Application number: 2024/91826	
What is the application for?:	Erection of single storey rear extension
Address of the site or building:	31, The Courtyard, Fenay Bridge, Huddersfield, HD8 0FT
Postcode:	HD8 0FT

User comments

Proposed rear/west facing elevation (1:100)

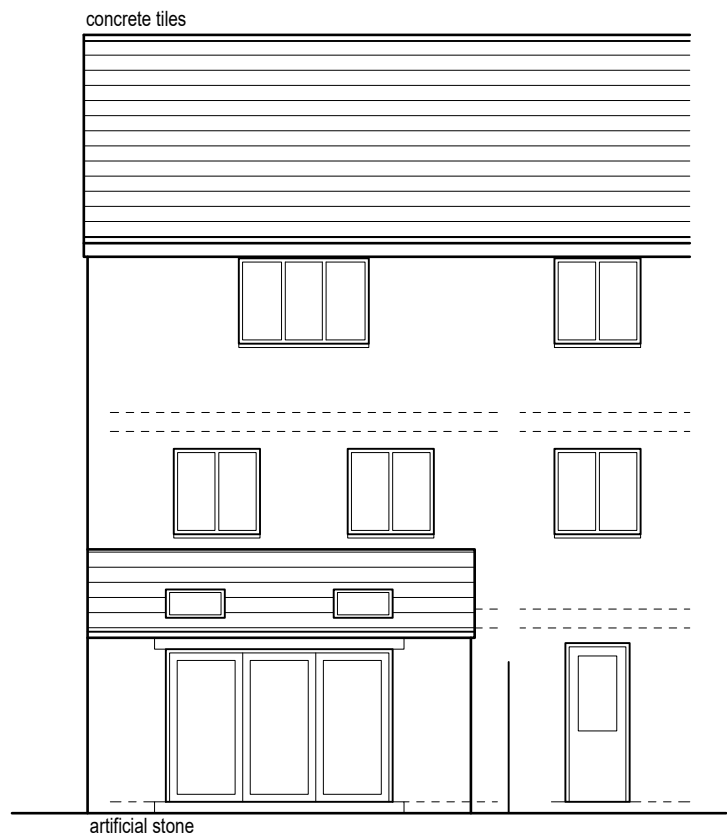
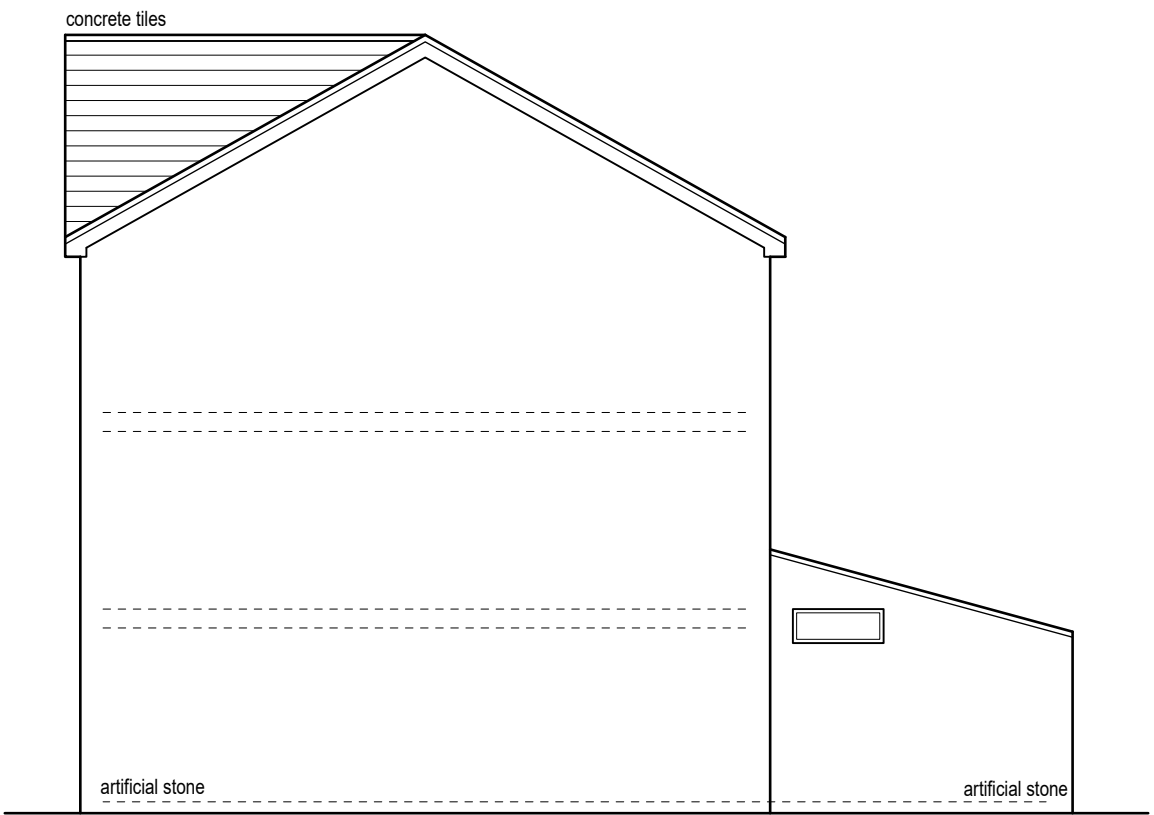
Type of comment: An objection	
Do you wish your comments to be published on the website anonymously?	No
We have no objection to the extension in principal however our objection relates to the new high level slit window in the upper part of the extension which if allowed, will enable our neighbour to look directly into our garden to which we do object as an invasion of our privacy. We note the extension has two large rooflights which will provide plenty of light into the extension without the need for this high level slit window and we would like this to be removed or lowered so that our privacy and enjoyment of our own property is maintained, we don't want our neighbours looking into our garden especially when in summer and is very perturbed and upset by this possibility. The reason we purchased this property is for the privacy it affords and this new slit window at the level it is proposed will destroy this, why cant the window be removed or lowered such that our privacy is maintain?
